Moorebank Intermodal Precinct West - Stage 3 (SSD-10431) - Public Exhibition

Thank you for your correspondence via the Major Projects portal on 27 April 2020, requesting Transport for NSW (TfNSW) to review and comment on the above.

Objective Reference CD20/03517

**Figure 5: Network Traffic Volumes, with MPW S2 - Scenario 2**

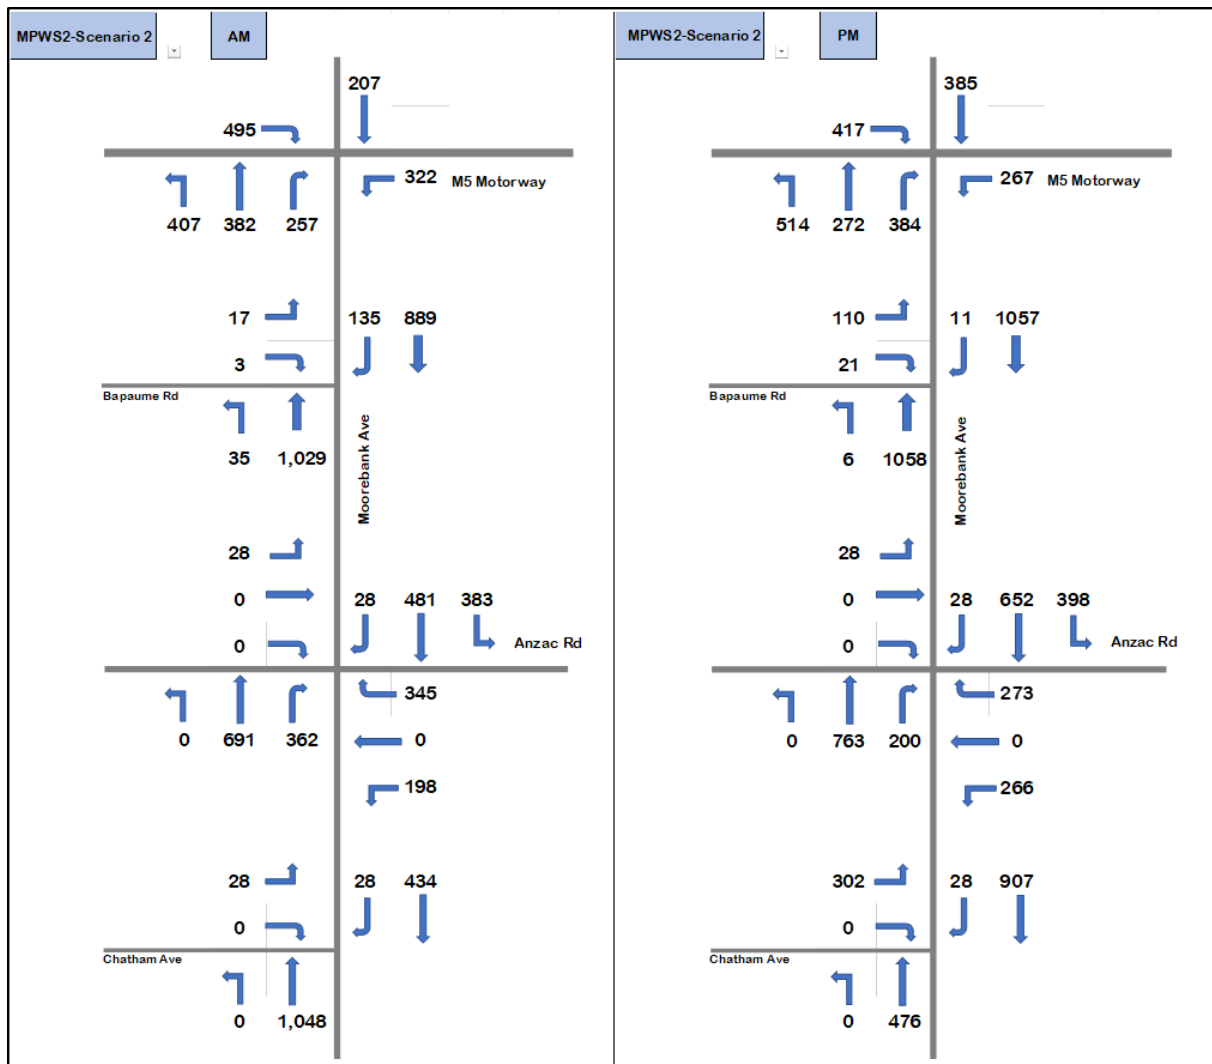
It is noted that Figure 5 of the Transport Assessment prepared to support the development application states that the traffic volumes included in Figure 5 are based on the Moorebank Precinct West (MPW) Stage 2 Proposal - Construction Traffic Impact Assessment, dated October 2016 (2016 MPW Report).

- Based on the traffic distribution adopted for Stage 2- Scenario 2 in Figure 5 of the Transport Assessment, number of construction vehicle movements included in Figure 5 are lower during the morning peak period and higher during the afternoon peak period compared to the construction traffic movements reported in the 2016 MPW Report; and
- Morning and afternoon traffic movements for Stage 2- Scenario 2 included in Figure 5 are not the same as traffic movements included in 2016 MPW Report for this scenario.

It is requested that the applicant clarifies the apparent inconsistencies between the Transport Assessment Report and the Moorebank Precinct West (MPW) Stage 2 Proposal - Construction Traffic Impact Assessment, dated October 2016.
